From: Liz Galloway [mailto:Lizgalloway@arundel.gov.uk]
Sent: 27 November 2012 15:07
To: Peter Cleveland
Subject: RE: A/112/12 THE LAMB, ANGMERING
Attachments: 12044 NEWBON The Lamb Oct 2012-A3 EX & PROP BLOCK PATIO R1.pdf; 12044 NEWBON The Lamb Oct 2012-REAR PATIO R1 A1.pdf; 12039 D&A Statement REAR PATIO R1.pdf

Sent: 26 November 2012 14:00
To: Peter Cleveland
Subject: A/112/12 THE LAMB, ANGMERING

| Issue          | Details          | By | Date |
|----------------|------------------|----|------|
| DRAWING NUMBER | 11045/21 Decking |    |      |

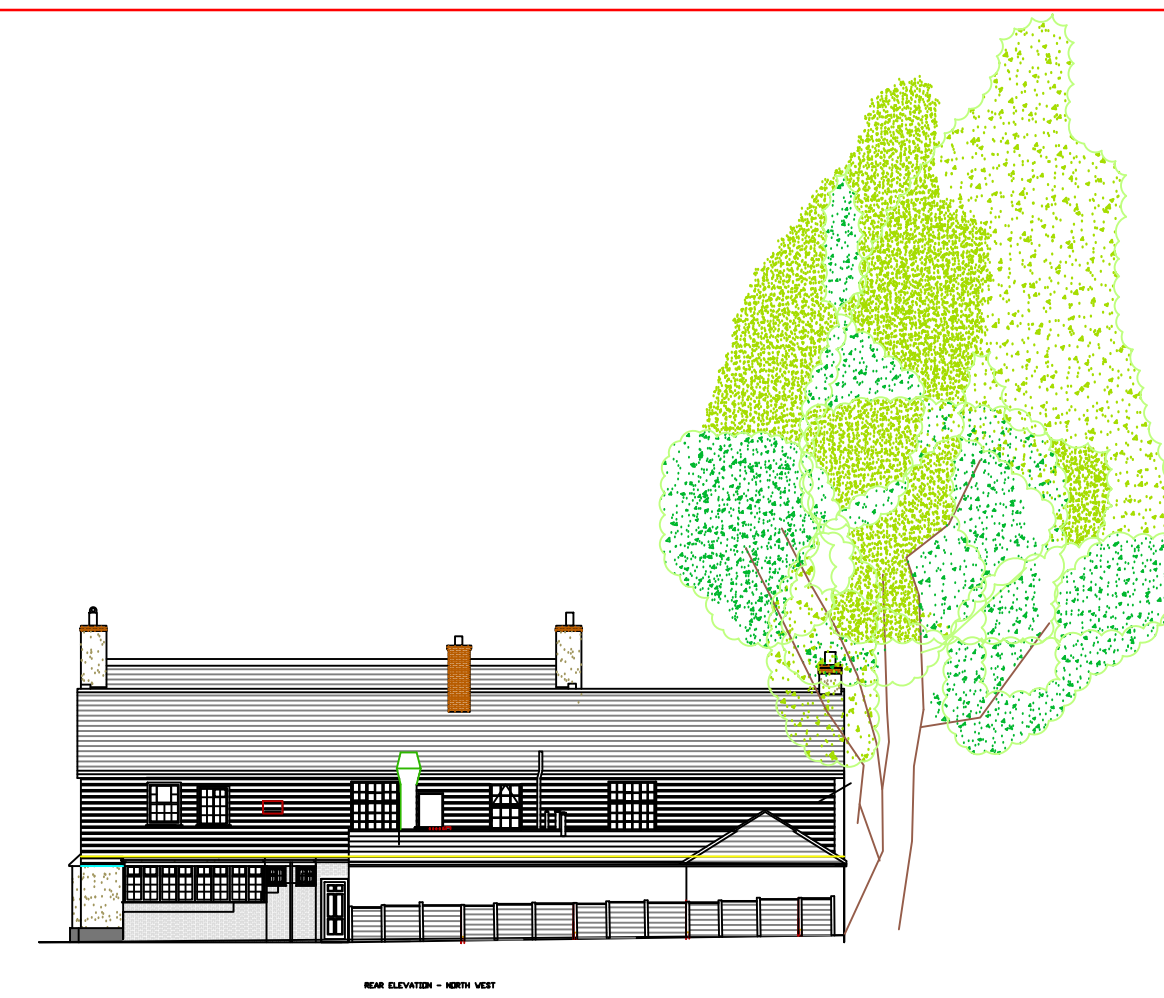
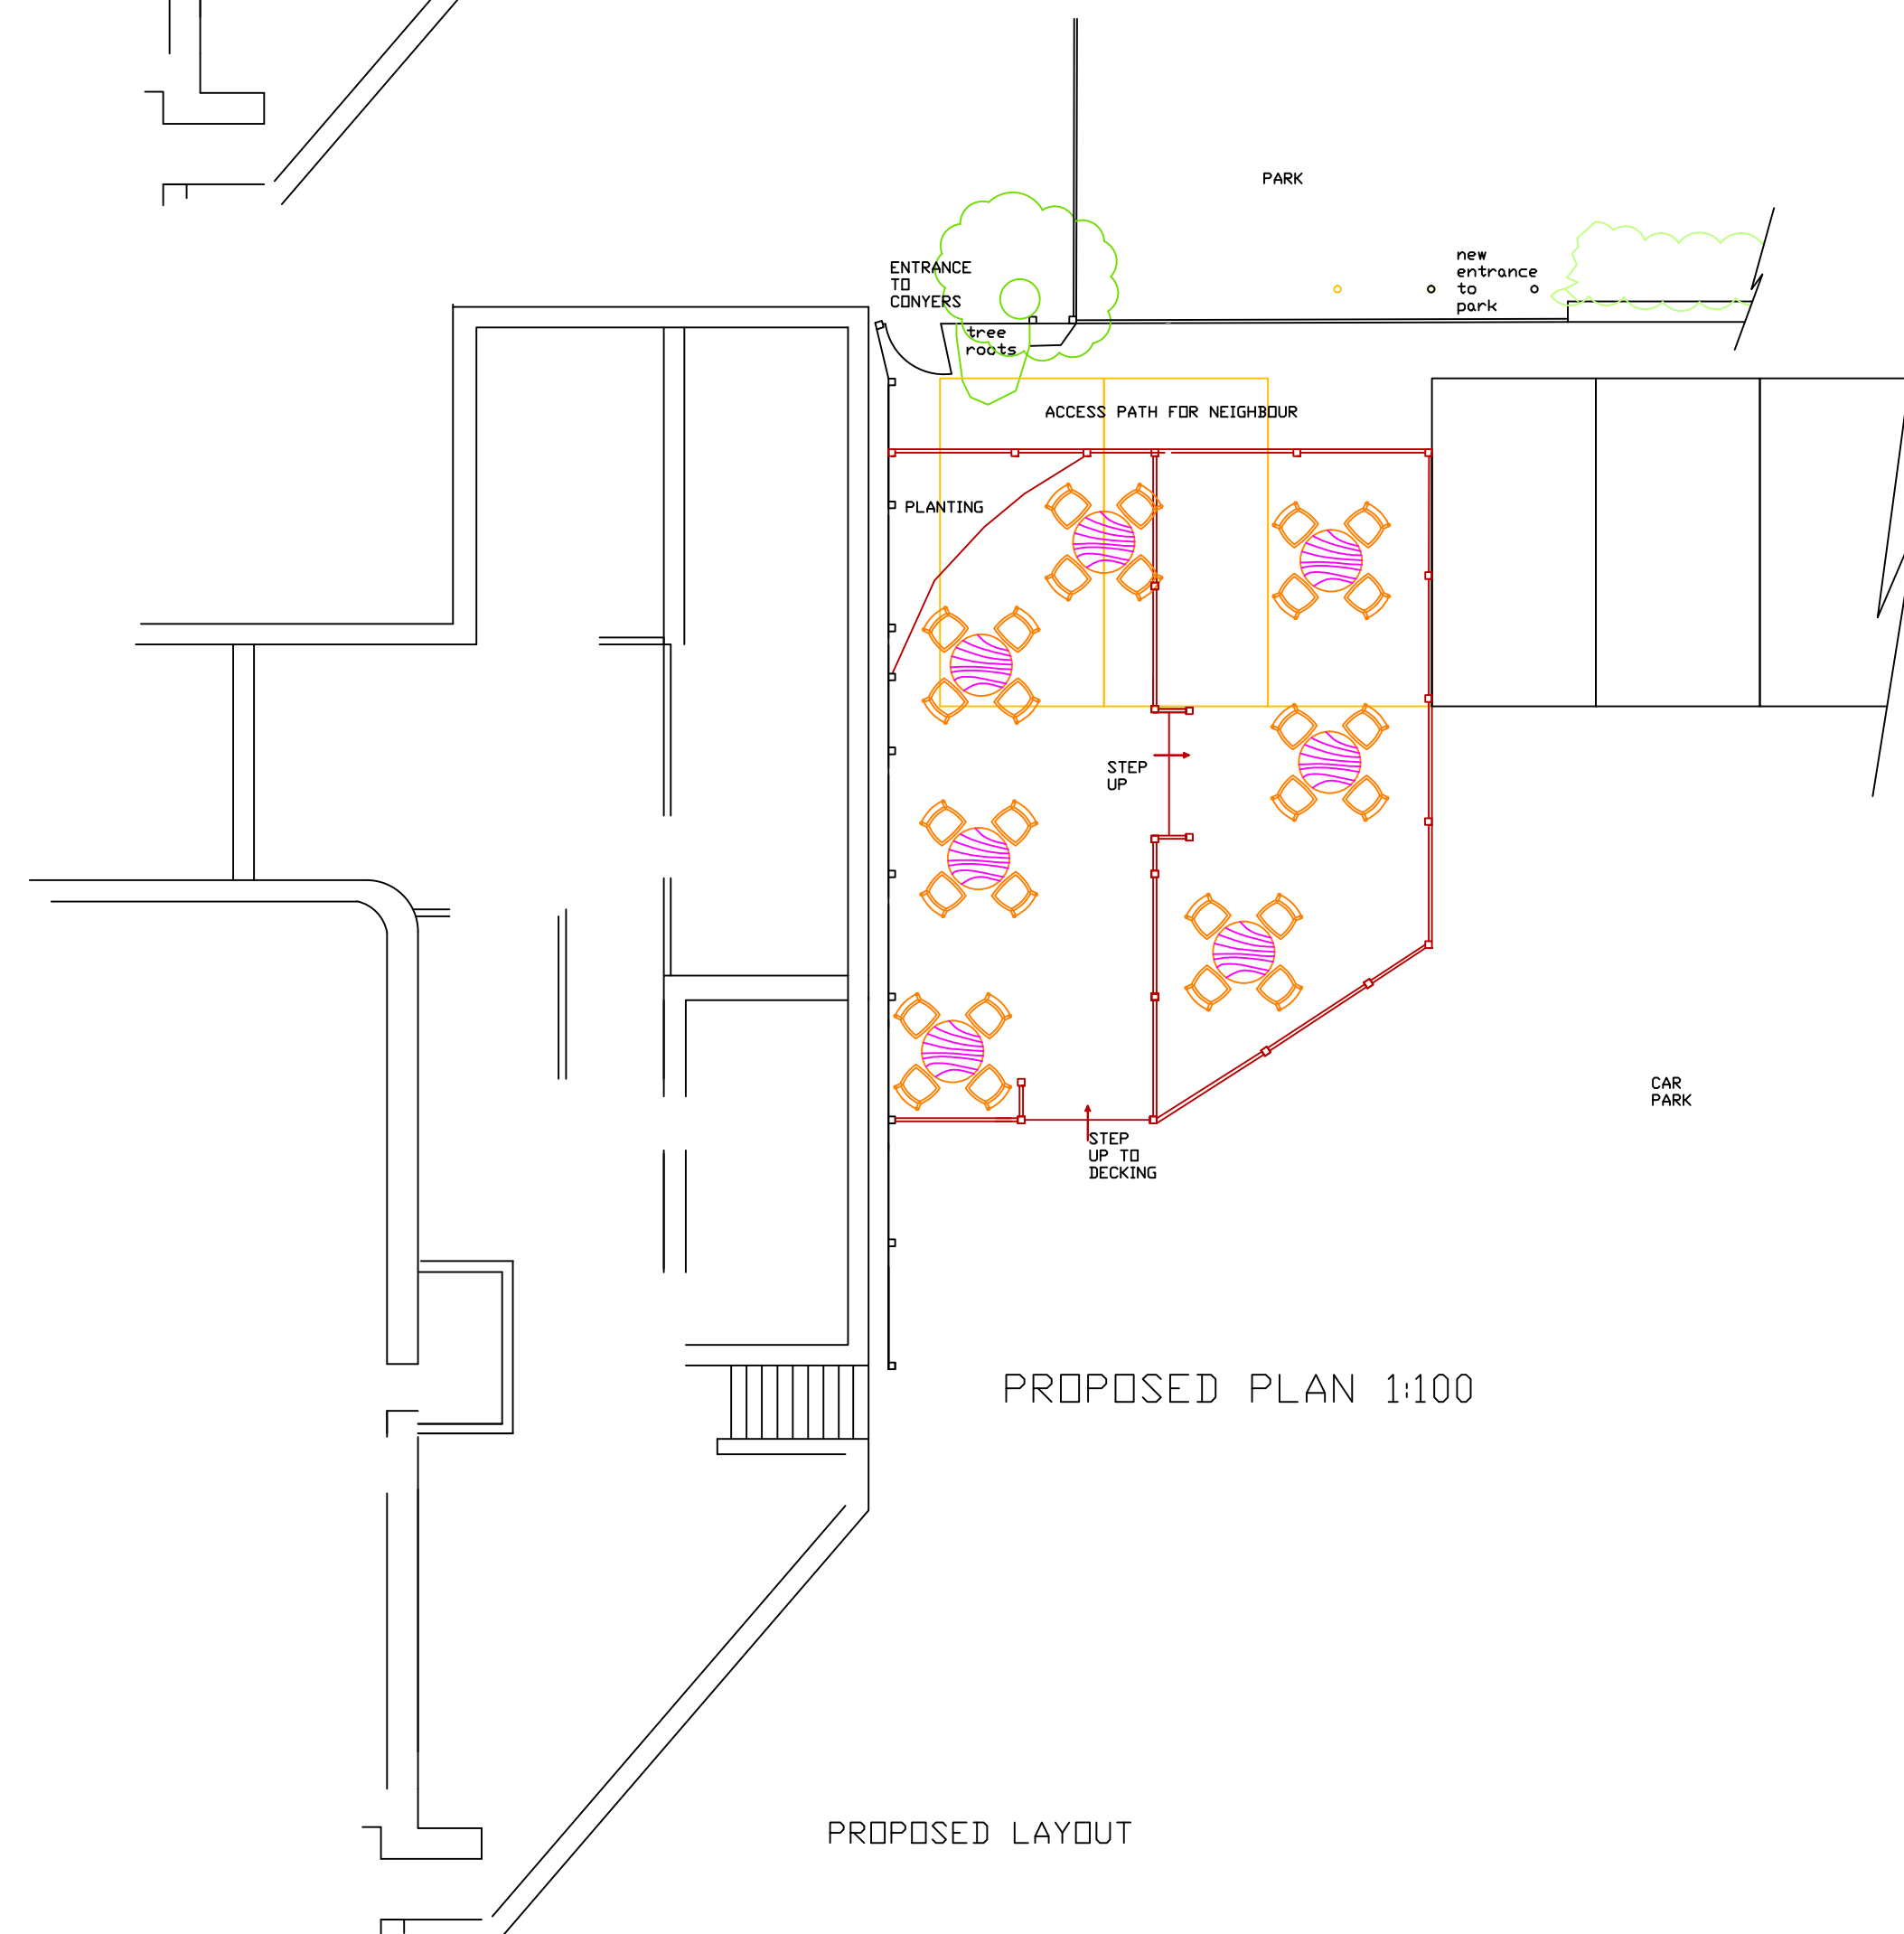
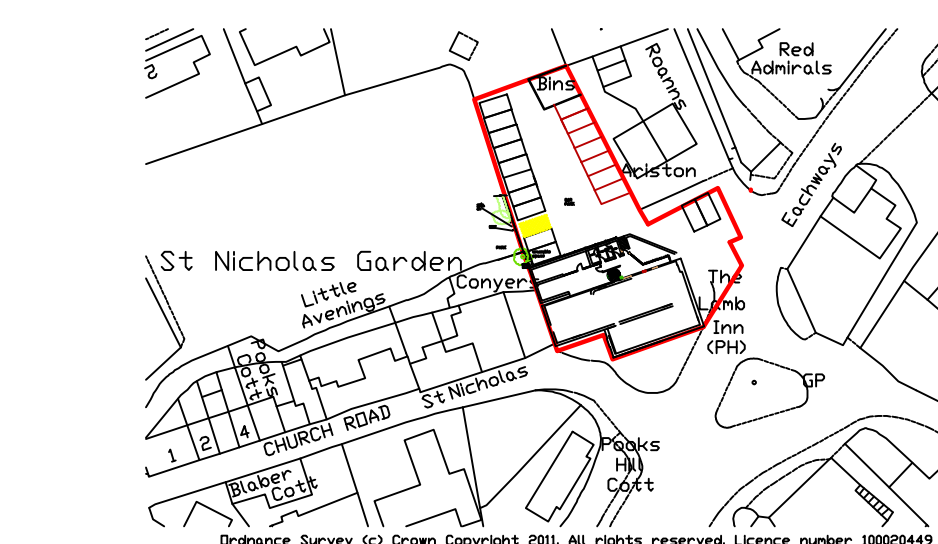
Thanks for the confirmation, having looked at it further though and considering how to amend the submitted plan, it will be best to amend the proposed plans as the elevations show the new detail and layout to the existing wall and I cannot just delete this from the plan.

Please delete reference to works to the boundary wall of St Nicholas Gardens and note this does not form part of the above Application as it is outside the ownership of the Applicant. The applicant and owner of the wall will be negotiating separately for any works to the wall. Please could you delete any relevant notation on our drawing to this effect.

Please find revised drawings showing the existing park entrance unchanged on the proposed, and reference to it's alteration removed. I also attach a revised D&A Statement as this also included reference to the park entrance being moved.
